KITITIAS COUNTY

MEMORANDUM

TO: All Staff
FROM: Public Works Plan Review Team
DATE: May 6, 2022
SUBJECT: VA-22-00002 Heidt

ATTACHMENT 2

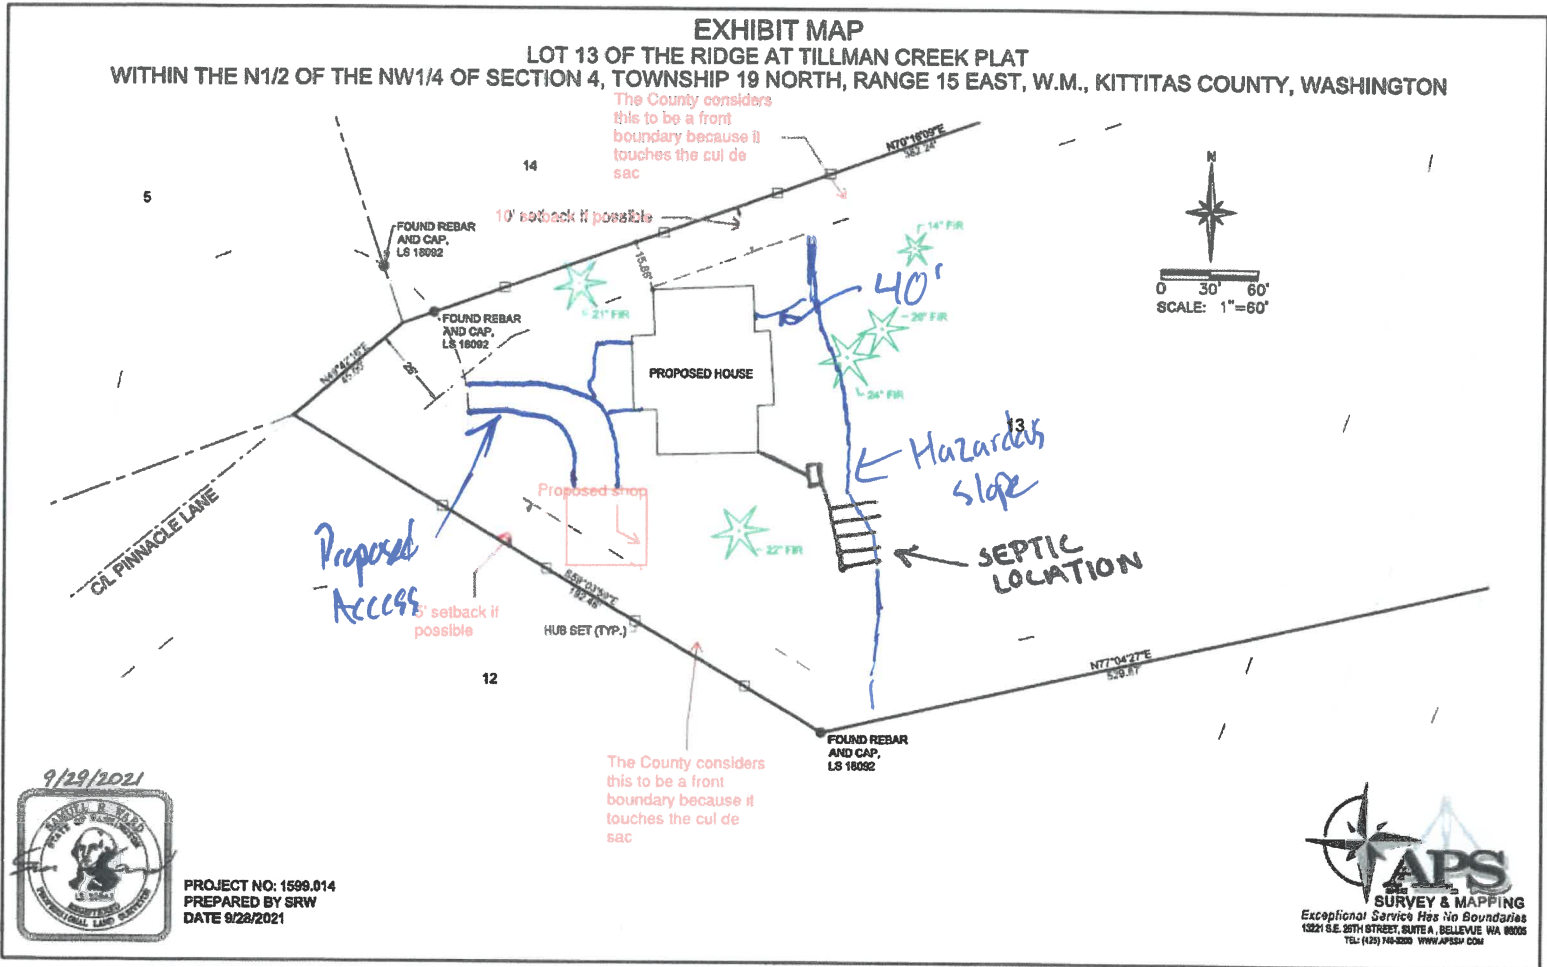
1. Distances on exhibit map do not match the project description. The map may show a 5 feet setback, but it is not identified on the map. The project identifies a 10 feet setback, but the map identifies a 15.96' feet setback.

2. A five feet setback poses constructability problems without trespassing into the neighboring parcel. Public Works believes that a written statement from the neighboring landowner approving a short-term construction easement would suffice.

3. Building footings, grading, overhangs and swinging doors cannot trespass into the neighboring parcel.
4. Given the tight tolerances required, having the boundary line staked by a land surveyor prior to construction should be required.

5. All elements of map should meet the requirements of WAC:332-130-145
6. Snow storage in regard to the shop may land on neighboring property, suggest an agreement with neighboring property for snow removal and/or storage.
